FULL

Reference: H16-1099-22 **Date of Decision:** 3rd January 2023
Applicant: M R & C M Senior
Dorma House
Monks House Lane
Spalding
PE11 3LH
Location: 33 Red Lion Street Spalding
Description: Installation of photovoltaic panels to south & west roof slopes

South Holland District Council hereby give notice that this application has been REFUSED for the above proposal for the following reason(s):

Scale 1:50 @ A1	Drawing No. 2209-01
Date. NOV. '22	Drawn. J.C.

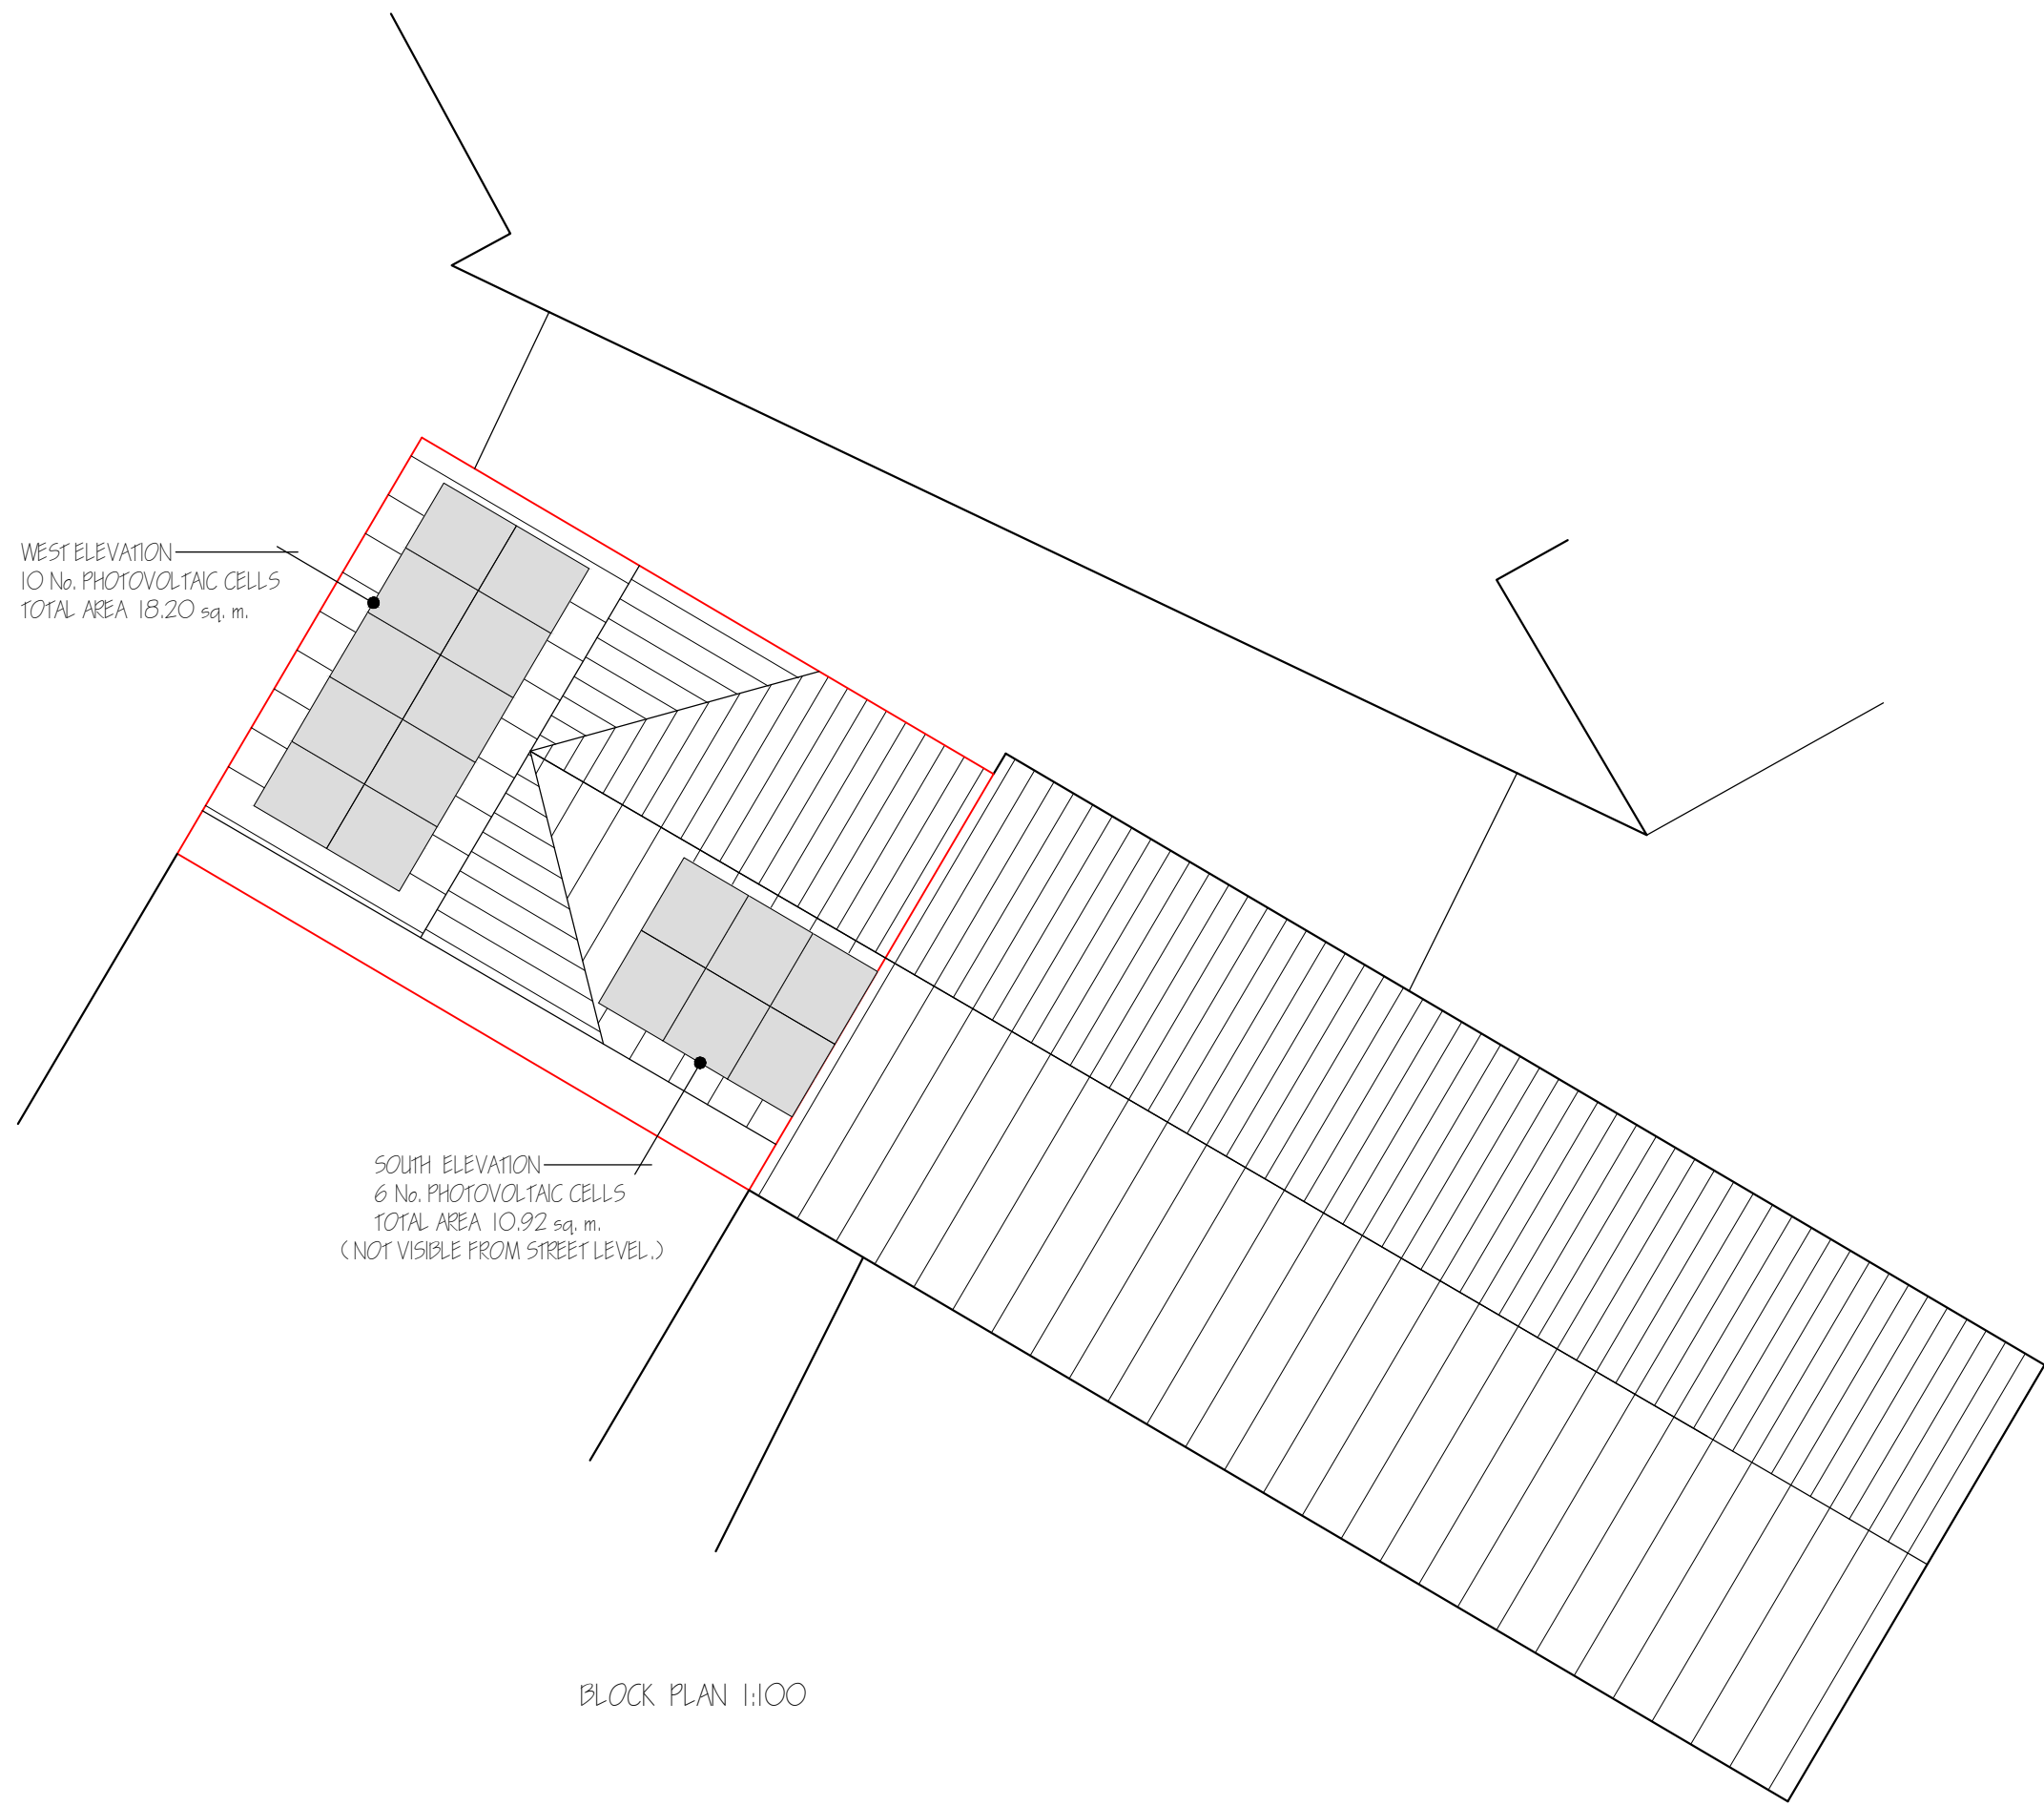
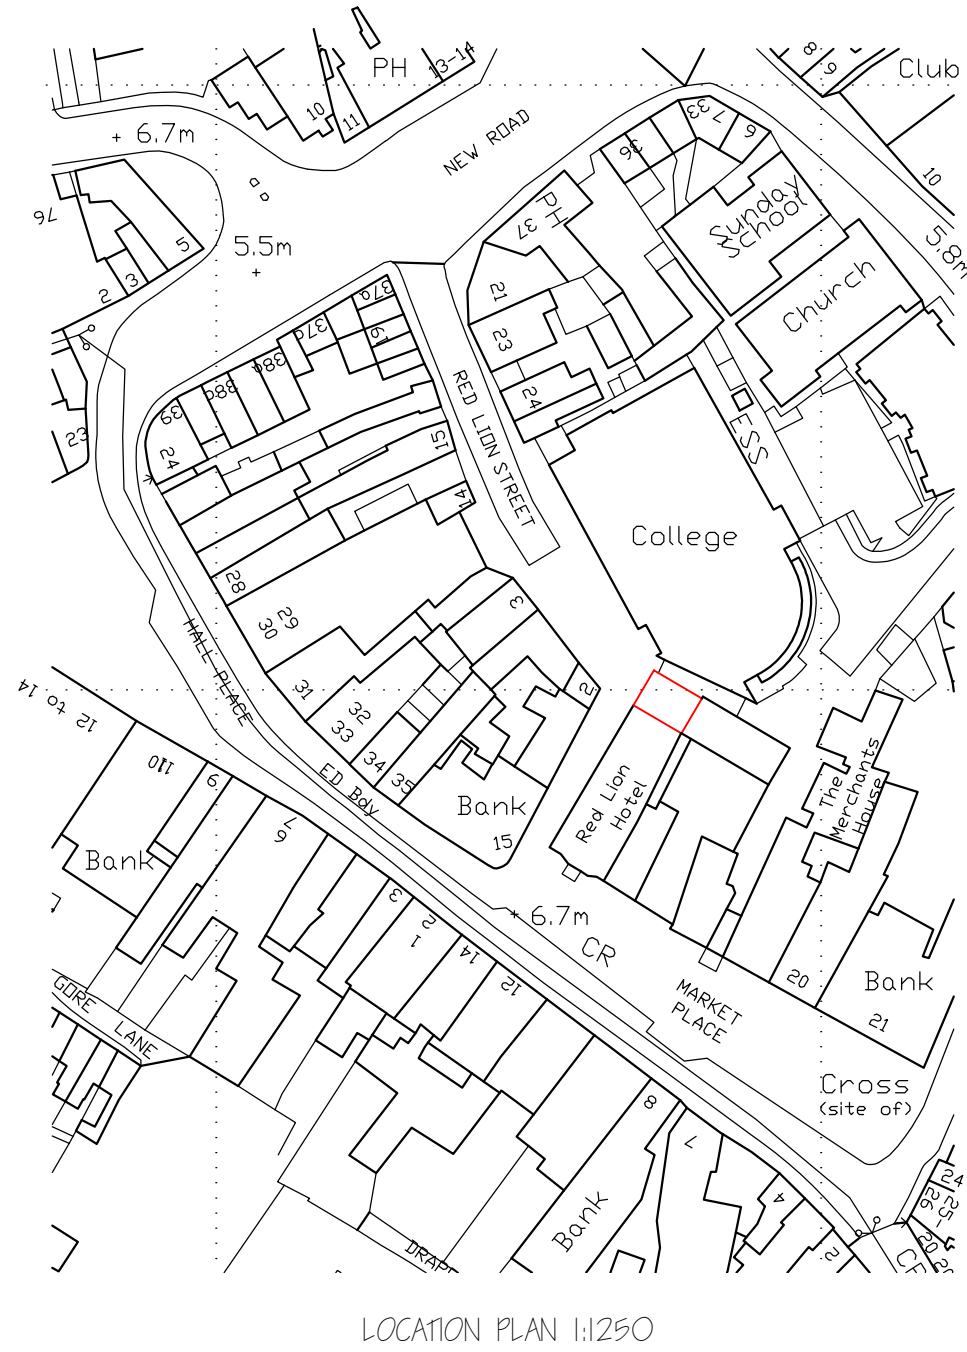
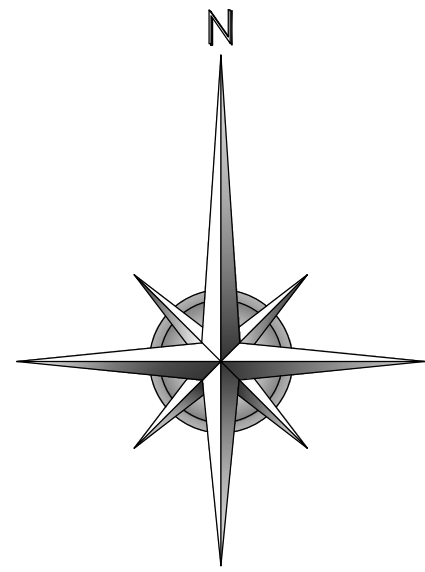
- 1 The introduction of photovoltaic cells to this property would fail to comply with the requirements of Policy 29 of the South-East Lincolnshire Local Plan (2019) and Section 16 of the National Planning Policy Framework (2021), both of which set out an obligation for Local Planning Authorities to preserve or enhance the character or appearance of the conservation area. The loss of slate roofing, in favour of photovoltaic cells which have a modern appearance, would cause a significant change in the appearance of the area. This change would directly contradict the aforementioned policy obligation to preserve or enhance the appearance of the conservation area.

- 2 The addition of photovoltaic cells would create an incongruous visual feature that would undermine the integrity of the conservation area. The importance of maintaining a consistent aesthetic, that conforms to the sense of character created within the conservation area, is particularly vital considering the site's proximity to a Grade II Listed building. Therefore, the proposal would fail to achieve the goals of Policy 29 of the South-East Lincolnshire Local Plan (2019) and Section 16 of the National Planning Policy Framework (2021).

development of renewable energy facilities is only permissible if the proposed would not cause significant harm to heritage assets and their settings or causing harm to visual amenity. The introduction of photovoltaic cells would certainly harm the setting of a heritage asset (namely the Grade II Listed Red Lion). Furthermore, the prominence the rooftop has within the street scene of Red Lion Street means that such an alteration to 33 Red Lion Street would have significant impacts upon the local visual amenity. Therefore, the proposal fails to conform to Policy 31 of the South-East Lincolnshire Local Plan (2019).
